CITY OF ALBUQUERQUE

RE: **Matheson Park Elementary School Site Improvements** **H21-D036**
10809 Lexington St. NE PE Stamp: 6/21/2013
Grade & Drain Plan for Grading, Paving and SO-19 Permits

Based upon the information provided in your submittal received 06-24-2013, the above referenced is plan approved for Grading, Paving and SO-19 Permits, subject to the following **qualifications**:

SHEET
C-403

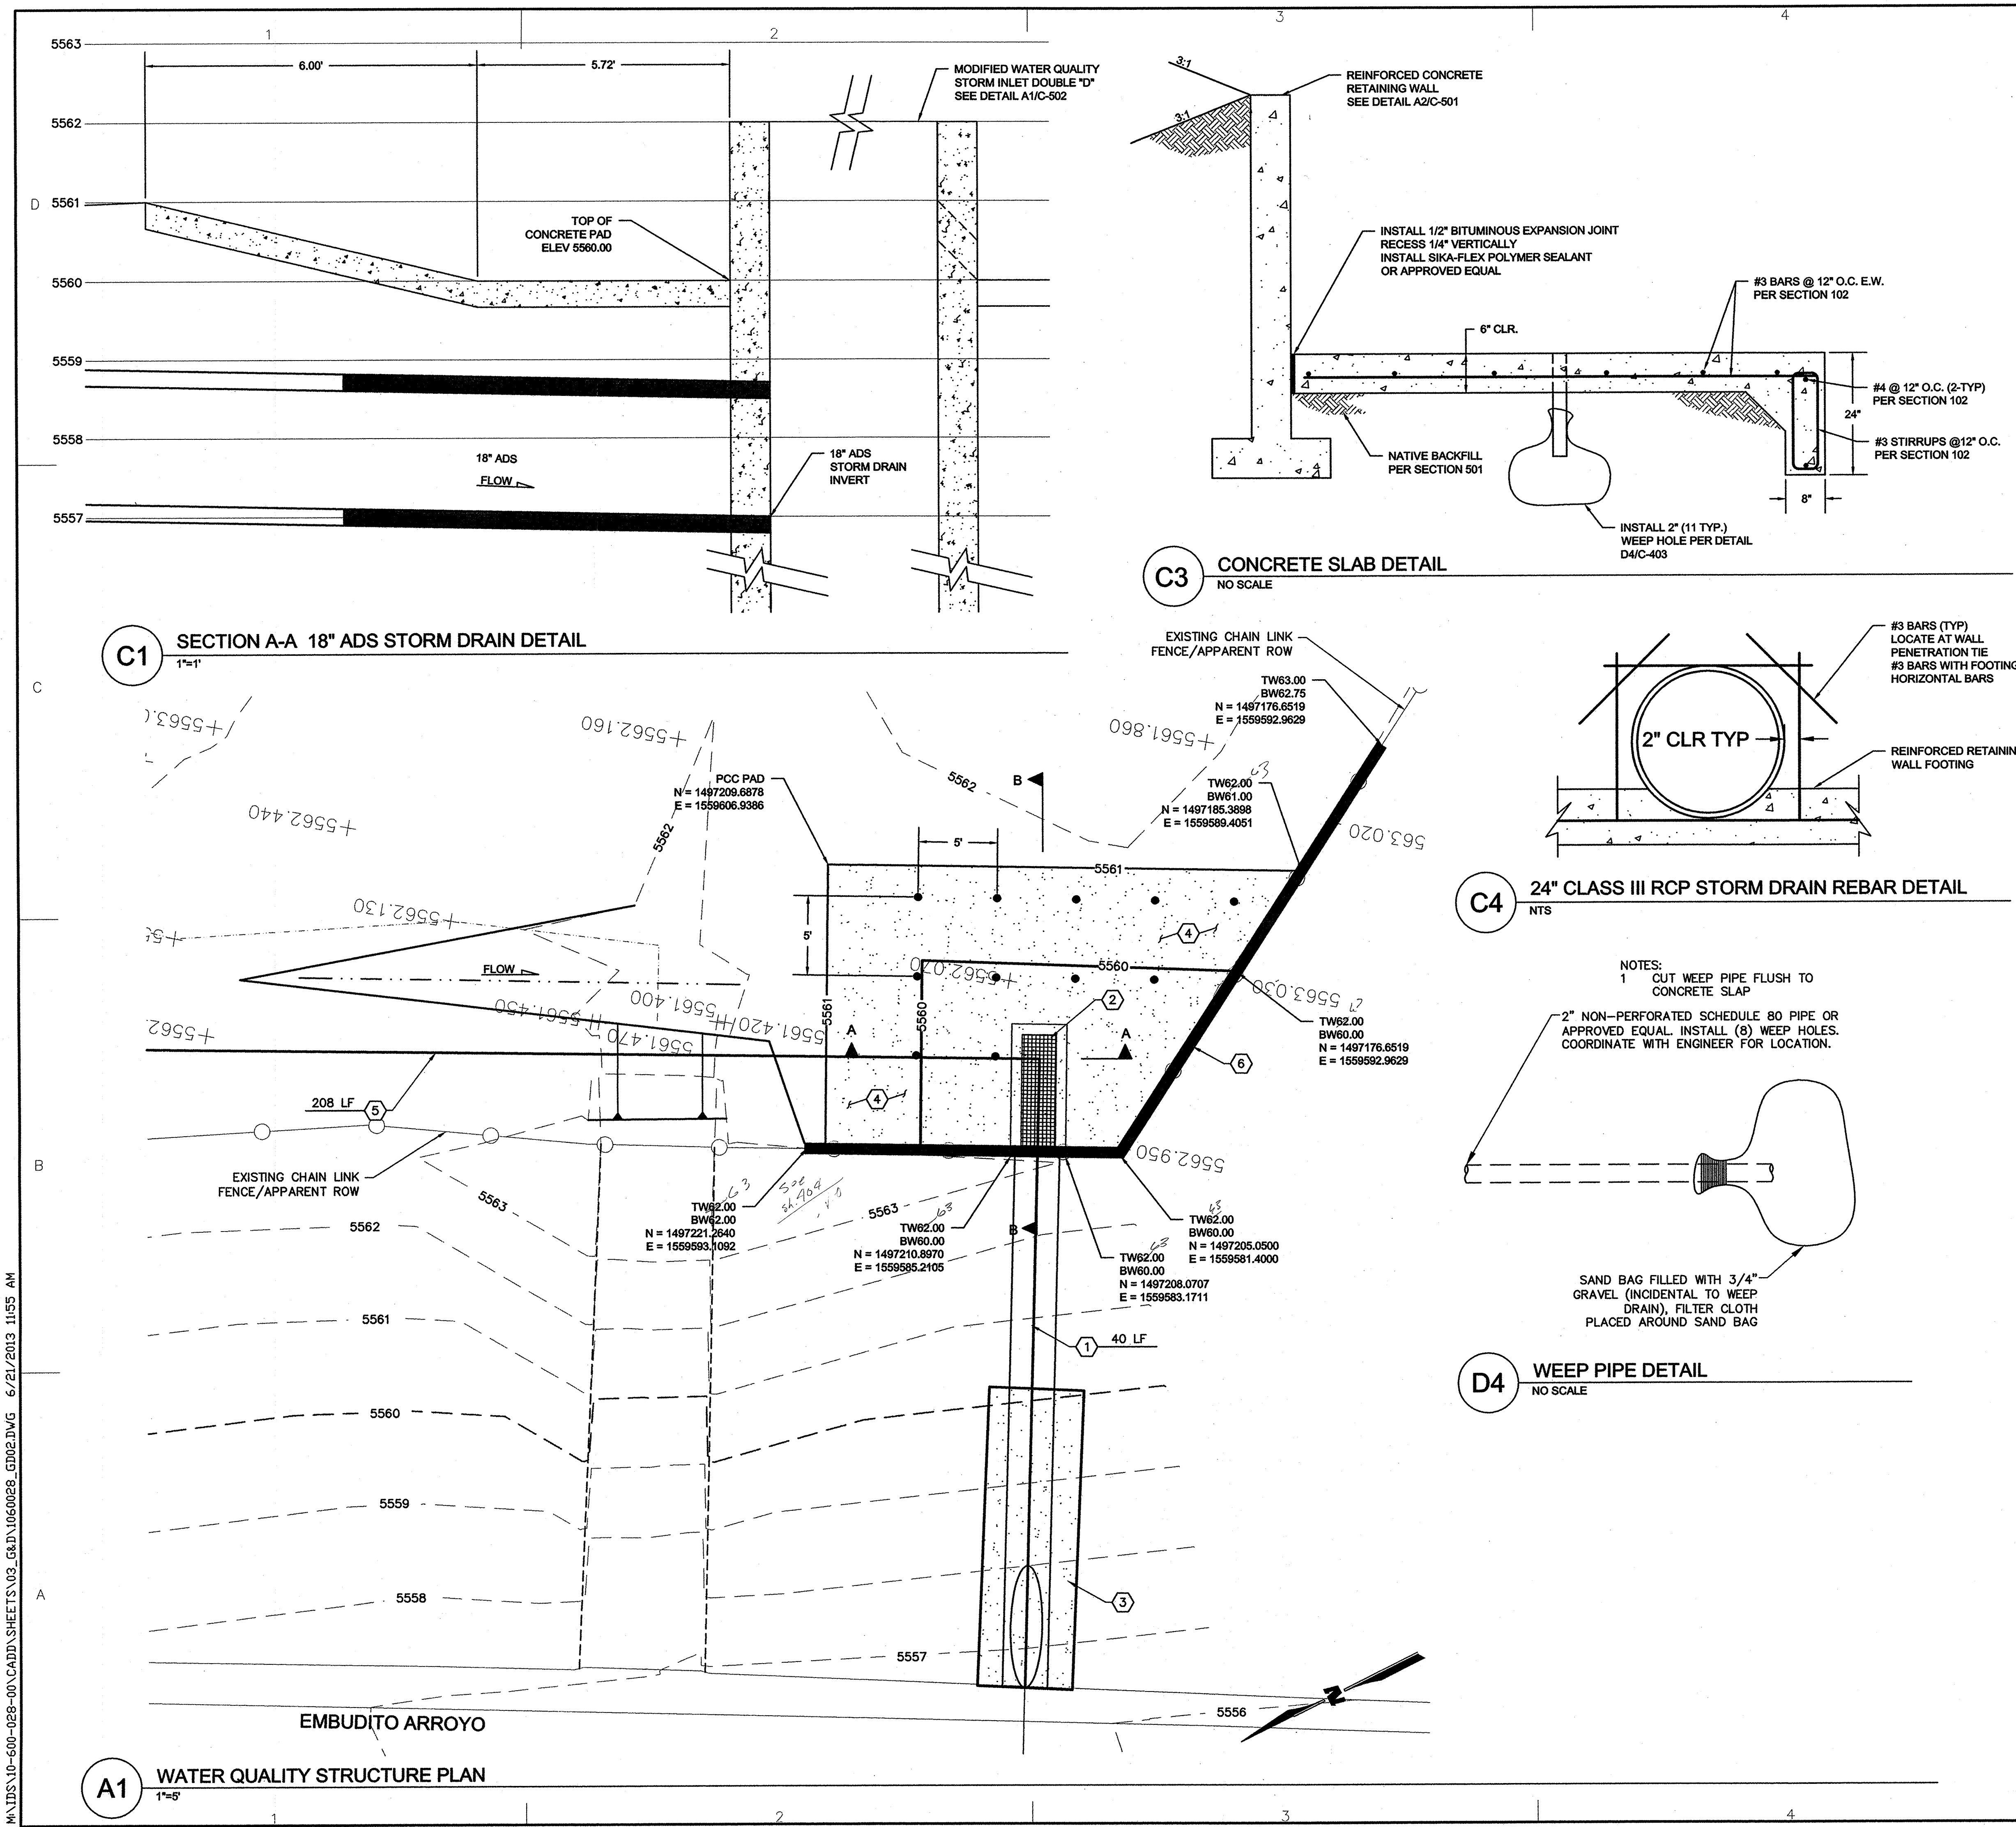
1. Sheets C-403, C-404 & C-501 (Detail A-2): Per conversation with Nicole Trujillo, Wilson & Co., on 7/10/13, the Top of Wall elevation at the SW corner of the site has been corrected to 5563.00, to match adjacent ground elevations. Please correct this on the affected sheets issued for construction, and on the As-Built Certification plan requested below.
